Ref: F12/72-05, LA33547

11 May 2017

MODIFICATION (2) OF PROJECT APPROVAL MP 08_0167 FOR A RESIDENTIAL SUBDIVISION, BELLE O'CONNOR STREET, SOUTH WEST ROCKS

STORMWATER MANAGEMENT

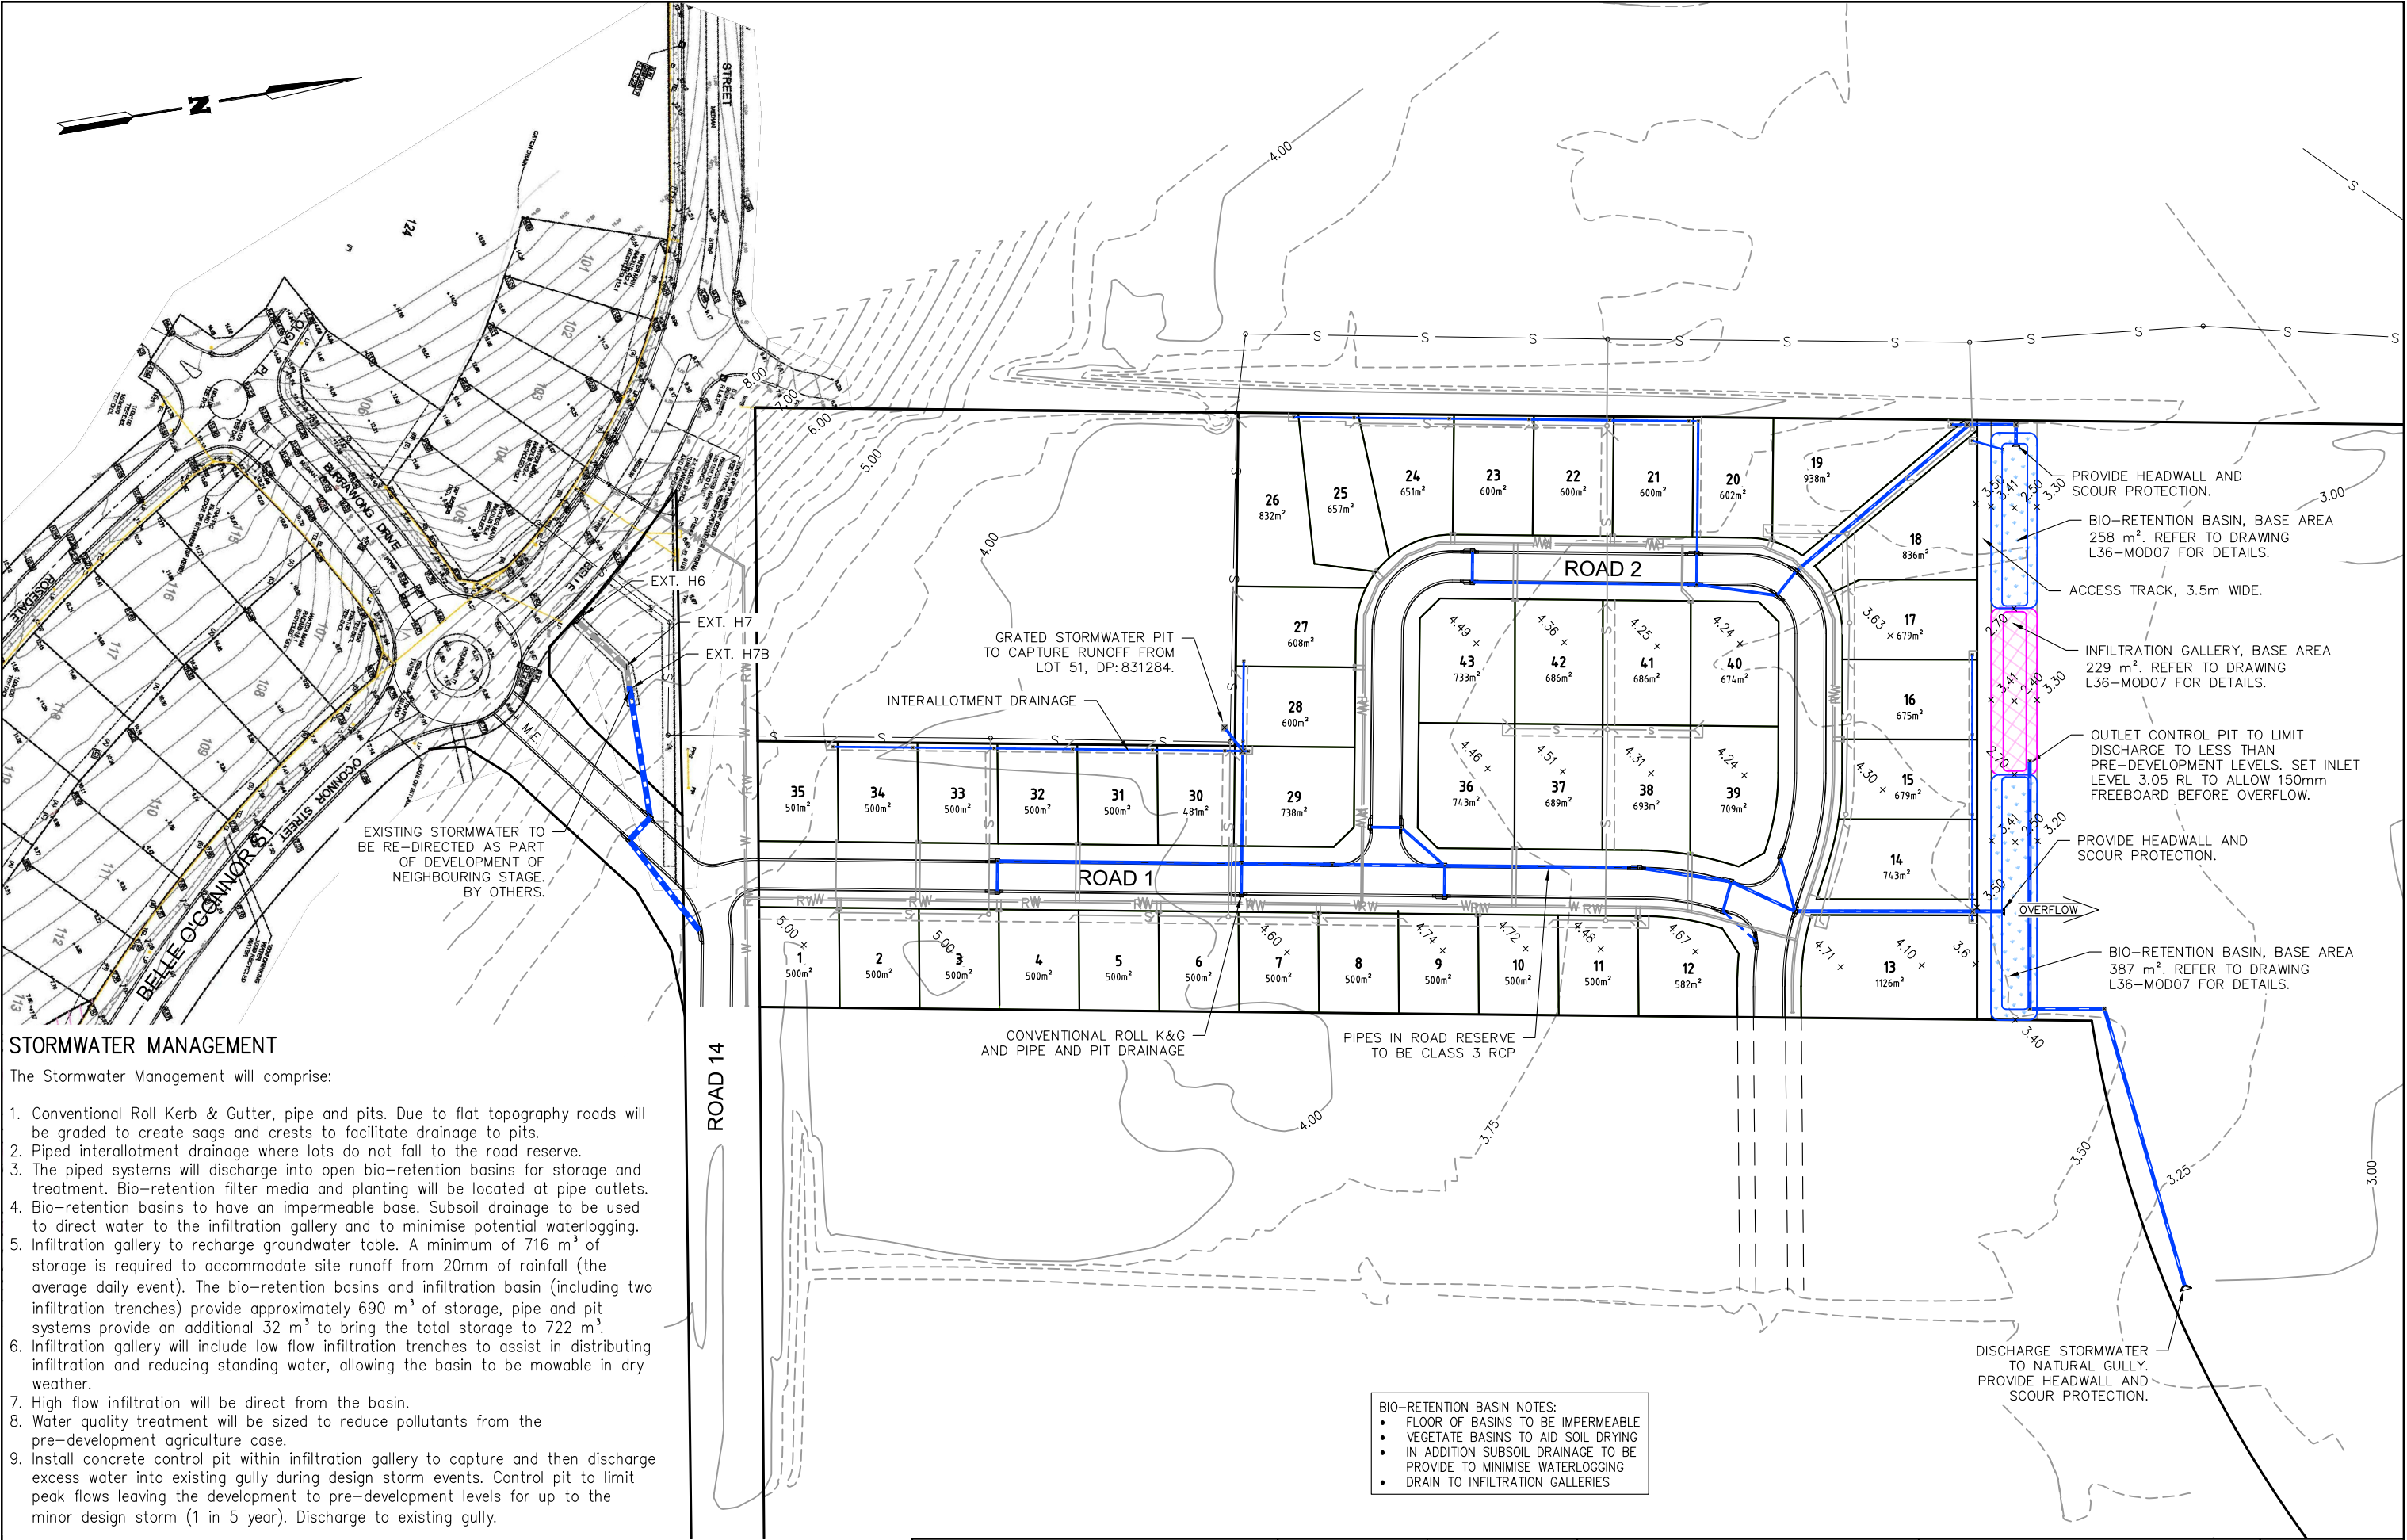
- c) The stormwater management infrastructure for Lot 36 is proposed on the adjoining and separate Lot 35. Whilst at present the two parcels are under the same ownership, how will this be addressed should this not be the case in the future? Furthermore, this land is zoned E2 Environmental Conservation under KLEP 2013 and such development is not only inconsistent with the objectives of this zone, but is also prohibited.
